Application No: EP/16/21/PL
Site Address: Land East of 1 The Way East Preston BN16 1QJ
Description of works: Replacement garage. This site is in CIL Zone 4 (Zero Rated) as other development.

Thank you for your internet representation made on 9th March 2021 which has been recorded as an objection with the comments as follows:

I am commenting on this application on behalf of the East Preston and Kingston Preservation Society.

Client: Mr D Lynch		
Project Address: The Garage The Way East Preston		
Drawing Title: Existing and Proposed Plans and Elevations		
Drawing Number: 1241.01.g		
Scale:	As stated printed @ A1	
Date:	06/01/2020

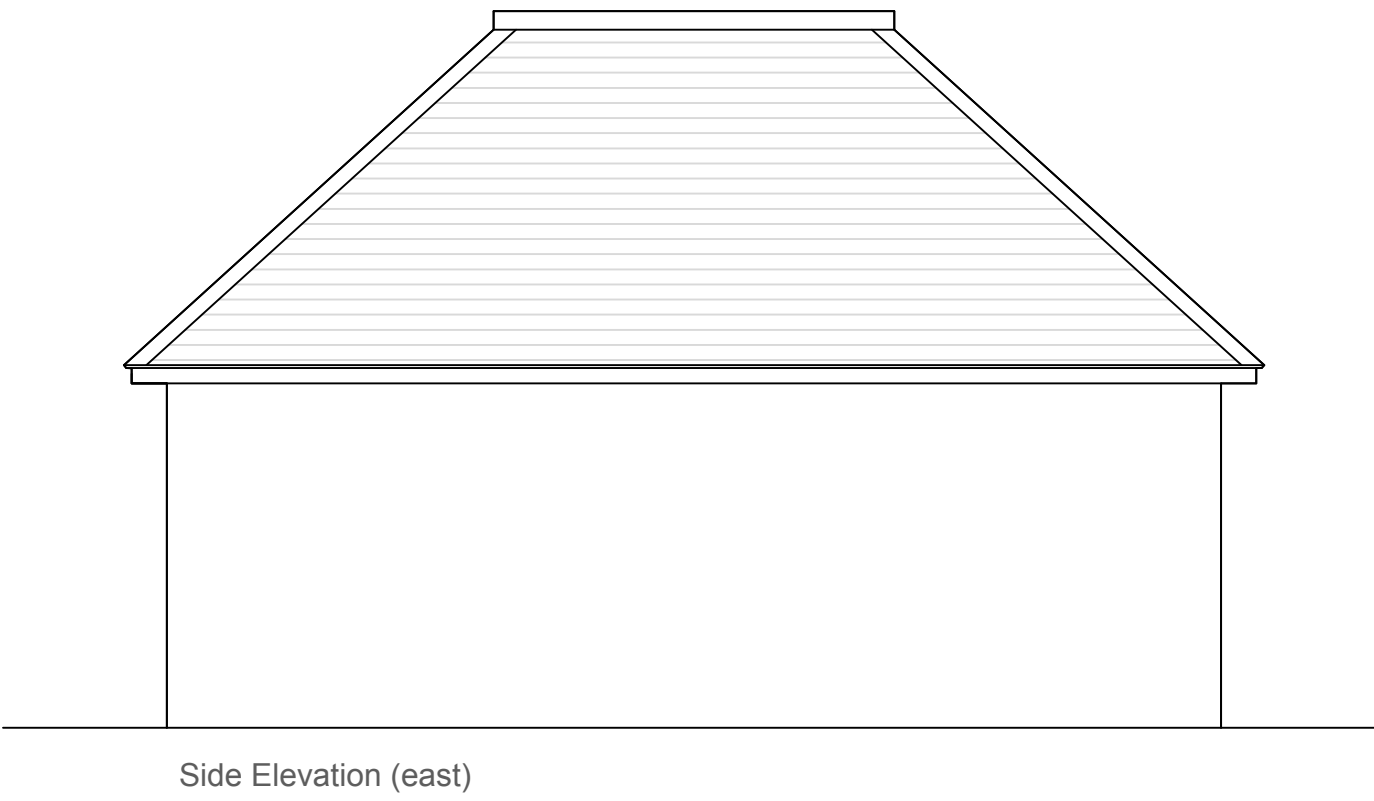
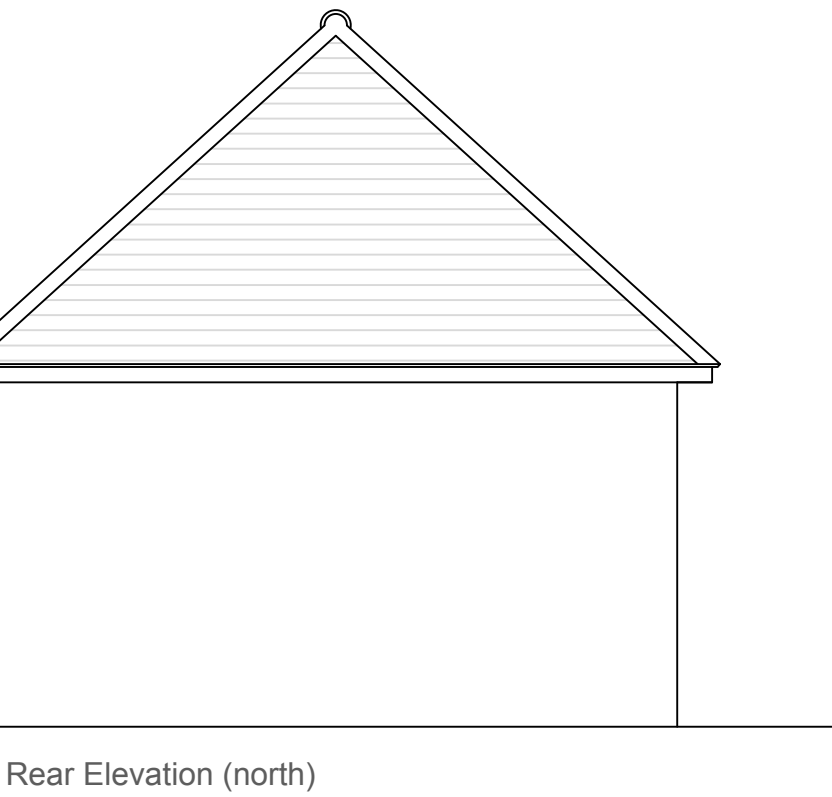
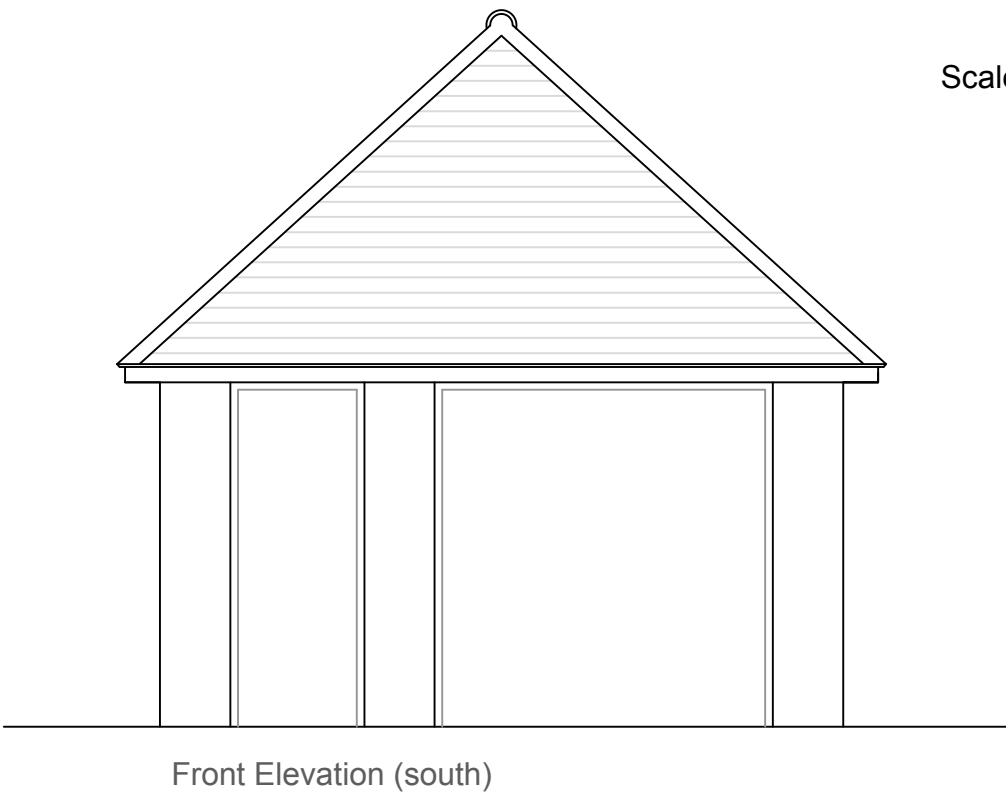
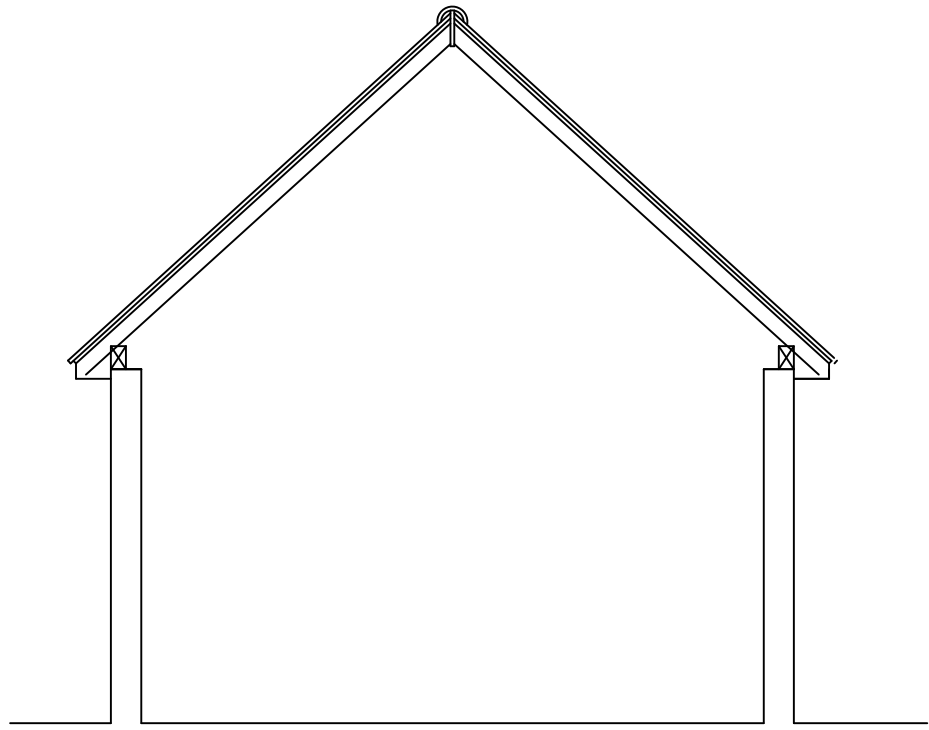
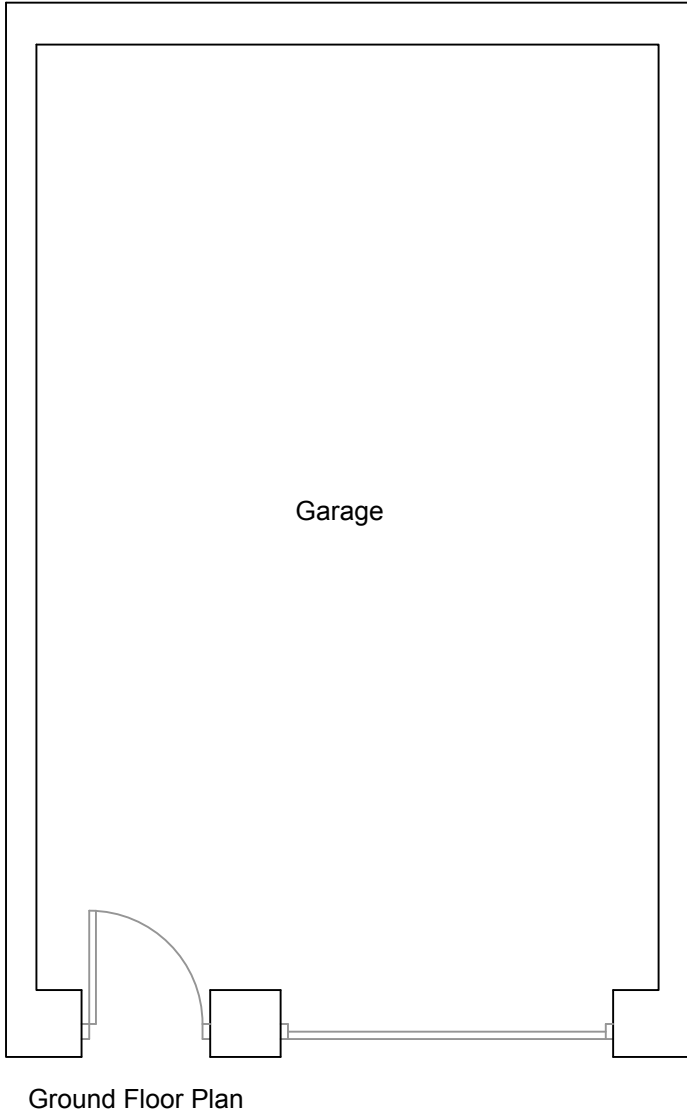
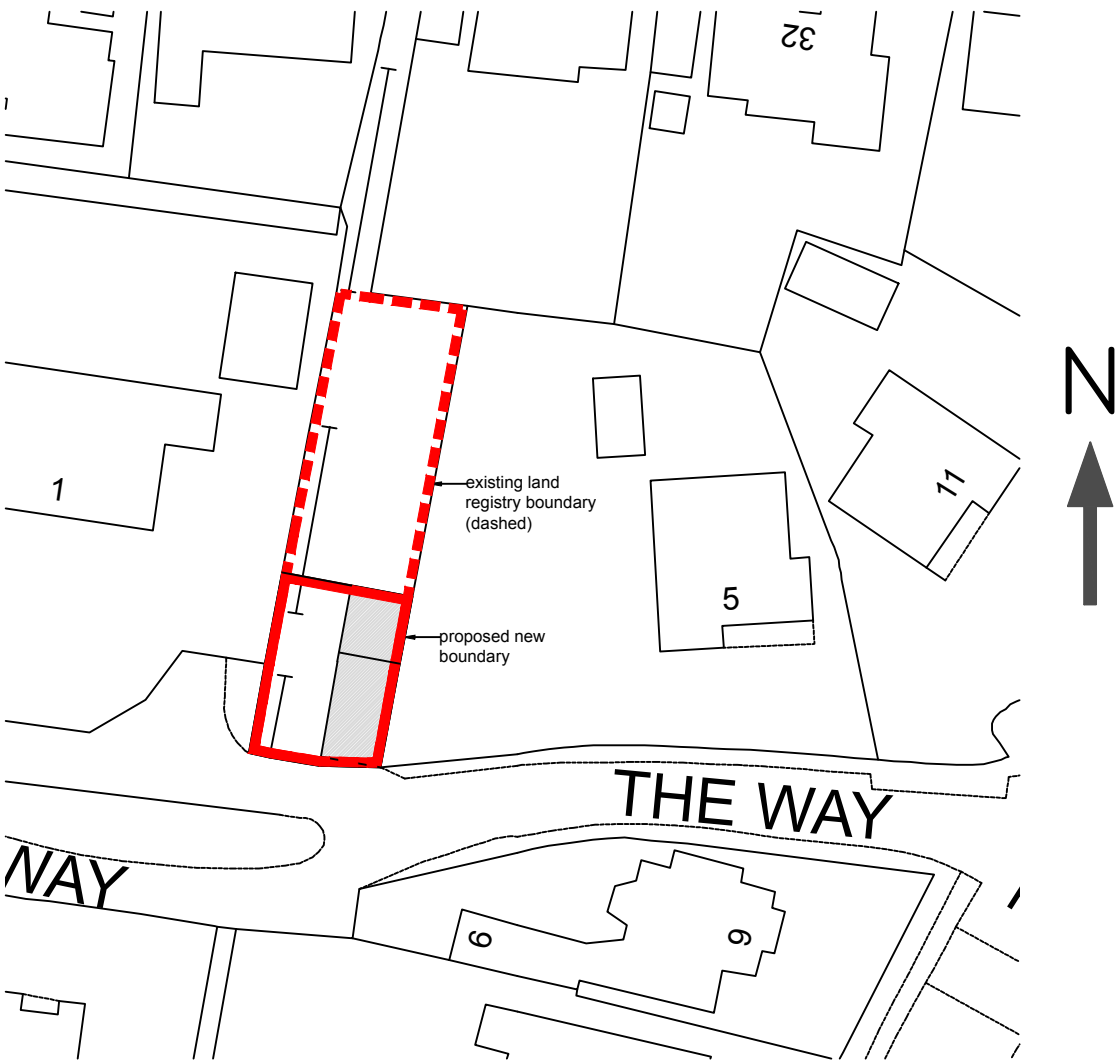
The proposed 2 storey building, garage with accommodation above, would replace a single storey garage with hipped roof. This garage, now partially collapsed, opens directly onto the road. Its door is 1.2 metres from the tarmac running surface of the road, which is 4 metres wide. The door and front wall of the garage was about 2.5 metres high.

The proposed building would be constructed on the footings of the old garage and would therefore be the same distance from the road. The new building would have a gable end at the road frontage, which would be about 5.5 metres high. It would therefore be about 3 metres higher than the road front of the old garage and its height would be greater than the width of the road. The effect on the road scene would be transformational.

The new garage would therefore stand far in front of its two neighbours.

Policy D DM1 of the Arun Local Plan states that new buildings should reflect the character of the area in which they are built in terms of, amongst other factors, their siting. A building placed directly on the edge of a road, in an area where existing buildings, including its neighbours, are set well back from a road, clearly conflicts with this policy.

development in this area should preserve the street scene. This proposal would transform the street scene.
